Job No: IAC-333

Reference: Entry Foyer Accessibility Review – Access Report
Development Application

ACCESS REPORT DEVELOPMENT APPLICATION

Project: Sydney Opera House
Eastern Offices
Document Type: Access Report – Development Application
Report Number: IAC-333

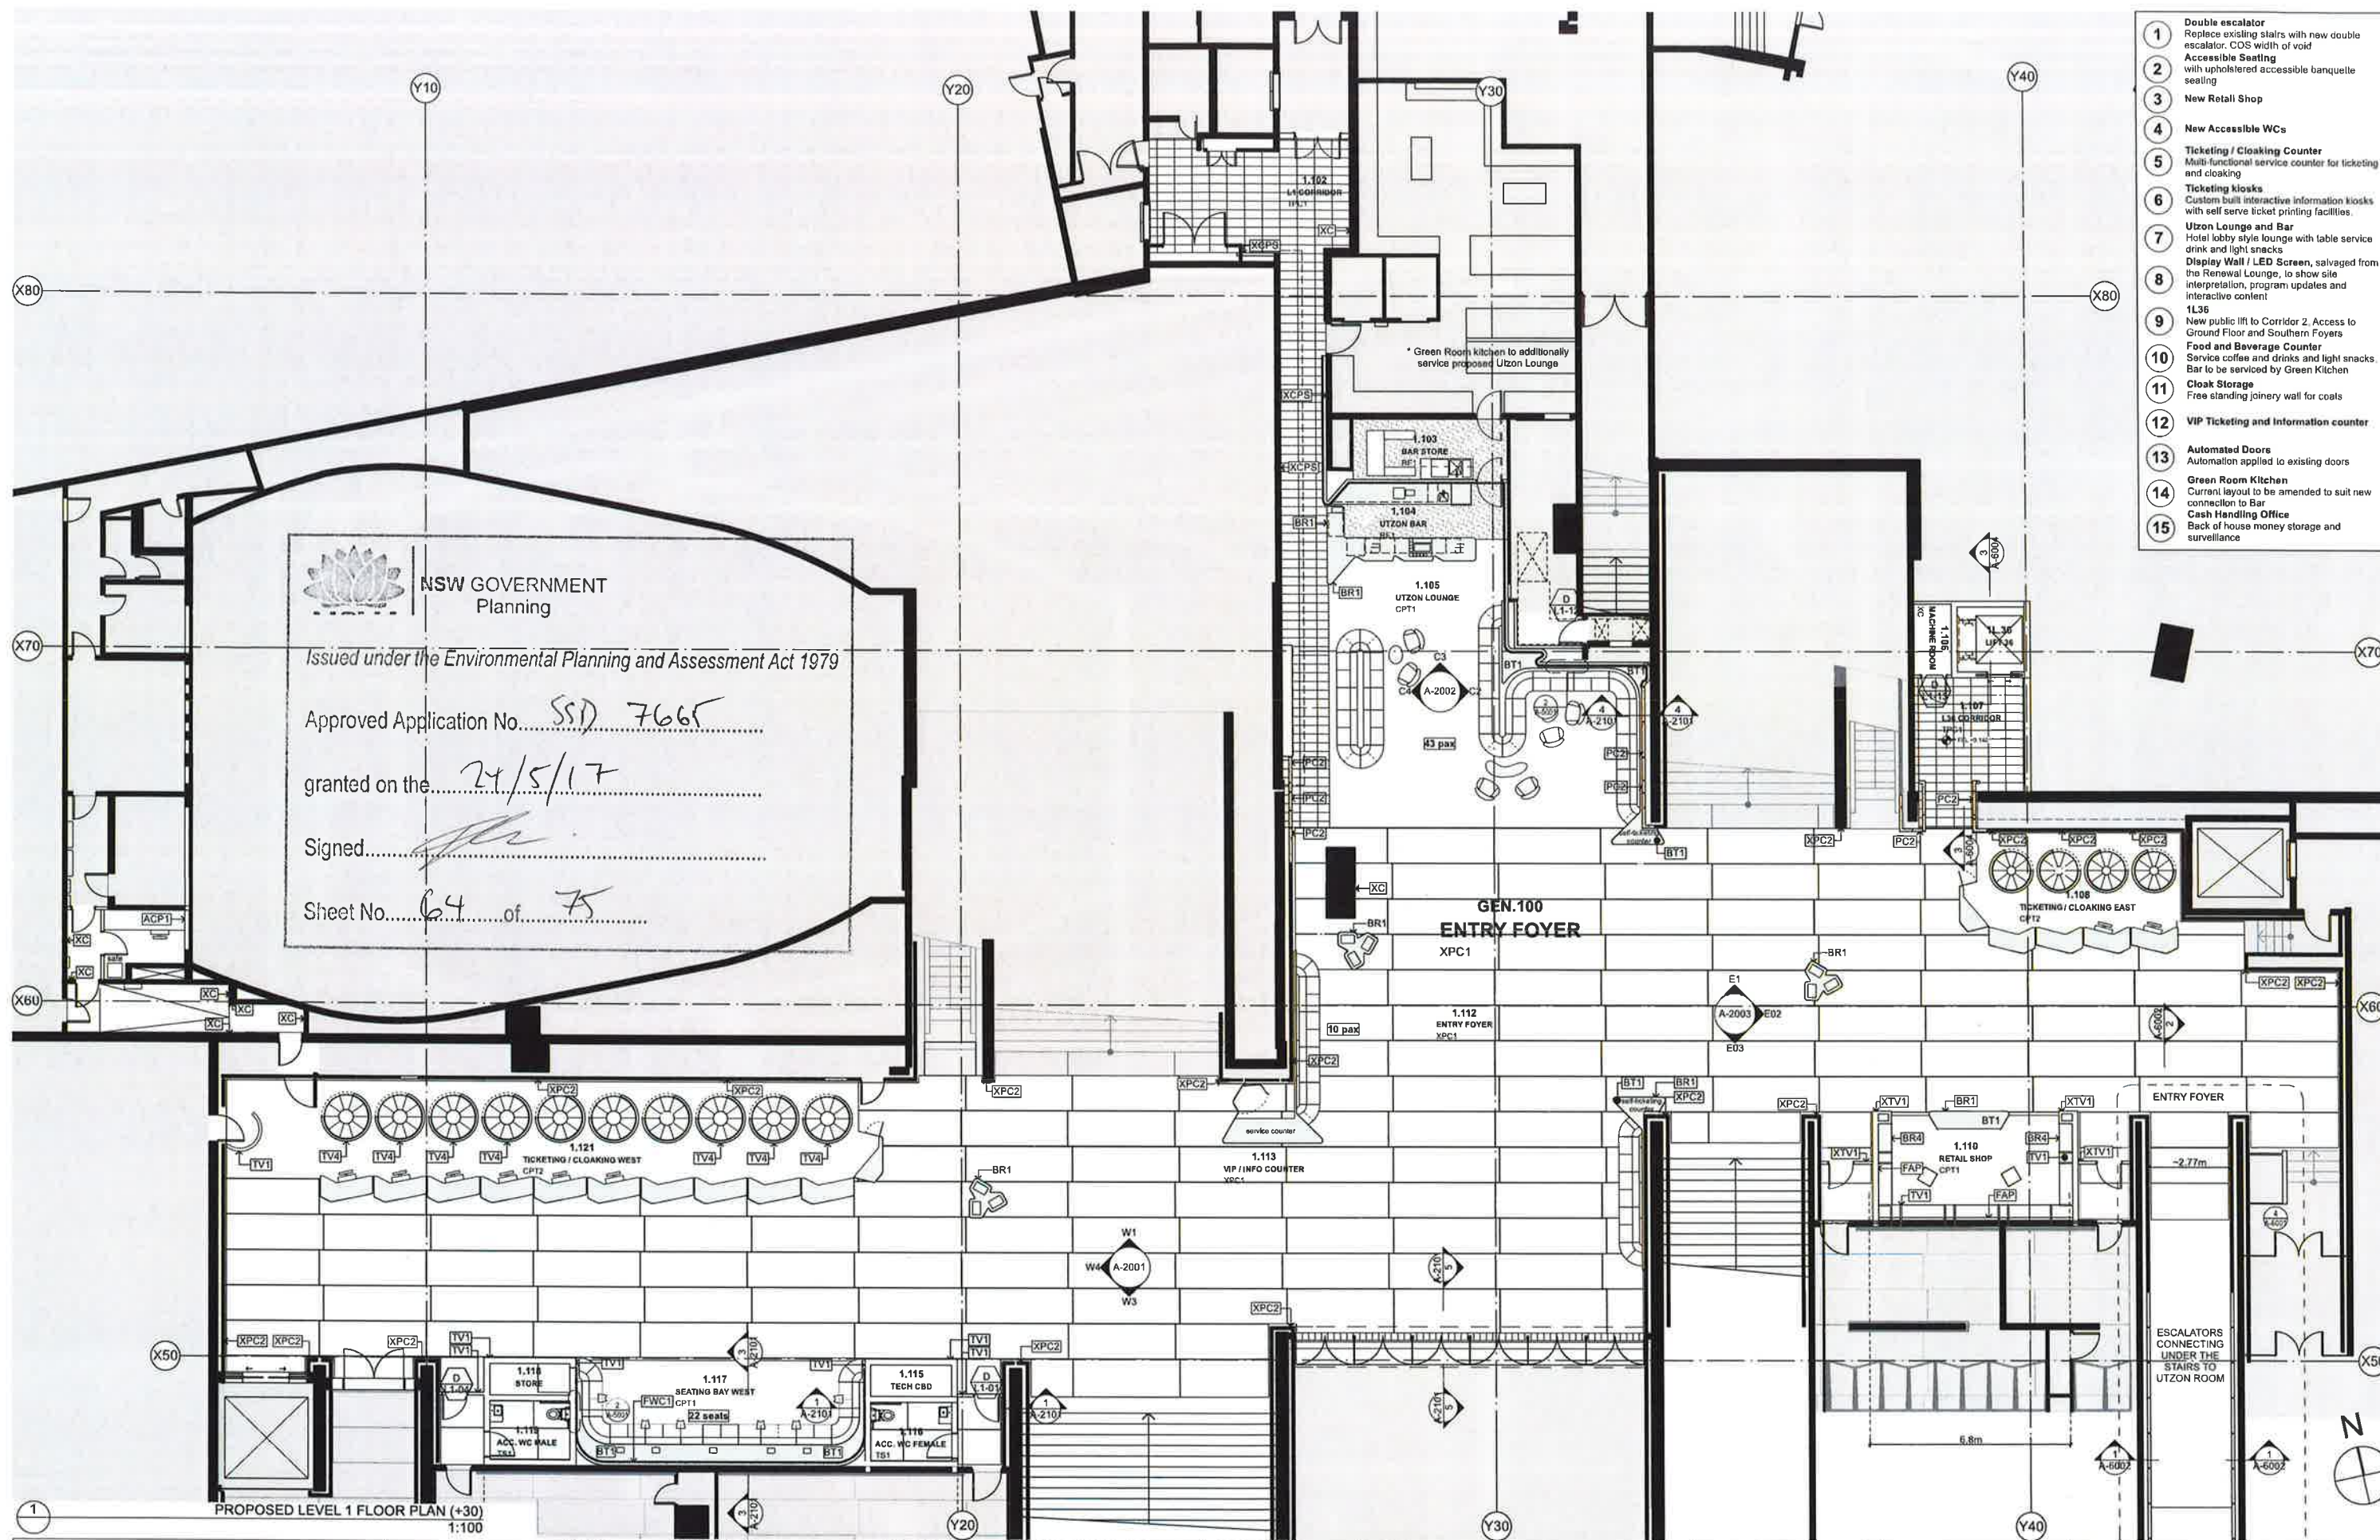
The plan indicates 3 seating areas which are located adjacent to the paths of travel.

The banquette seating will be custom joinery. It is recommended that the custom joinery incorporate the accessibility dimensions identified at Clause 27 of AS1428.2:1992 – Street Furniture to provide accesses to accessible seating for as many people as possible.

Seating zones outside of the path of travel should be provided for wheelchair users waiting to enter the various theatres. Companion seating should be provided adjacent to these wheelchair zones.

The detailing of accessible seating is to include for the provision of arms to some of the chairs. The following extract from the Standard provides some guidance as to the relationships of chair arms to the seat.

NCC Clause F2.4(c) requires that ambulant facilities be provided at each bank of WC facilities. In this instance the ambulant WC facility is proposed to be satisfied by the inclusion of a fold down grabrail installed within the accessible WC facilities located on the western side of the Foyer.

Braille Tactile signage will need to be provided to each entry door to the male and female WC facilities providing directions to the accessible WC facilities provided on the western side of the Foyer.

The bank of males and female WC facilities on the eastern side of the Entry Foyer does not make provision for ambulant facilities in accordance with the provisions of NCC Clause F2.4(c) and Clause 16 of AS1428.1:2009. It is proposed that a fold down grabrail be incorporated into the male and female accessible WC facilities. *A Performance Statement has been prepared to address this approach*

As these Accessible WC facilities are not collocated with the male and female WC facilities it will be necessary to provide braille tactile signage at the bank of WC facilities providing direction to the nearest Accessible WC facility.

The plan proposes cloaking areas on each side of the Entry Foyer.

Accessible access is provided on the patron side of the cloaking desk. The detail of the cloaking desk has yet to be finalised. The preliminary designs adopt the side on approach to the counter identified at Clause 22 of AS1428.2:1992.
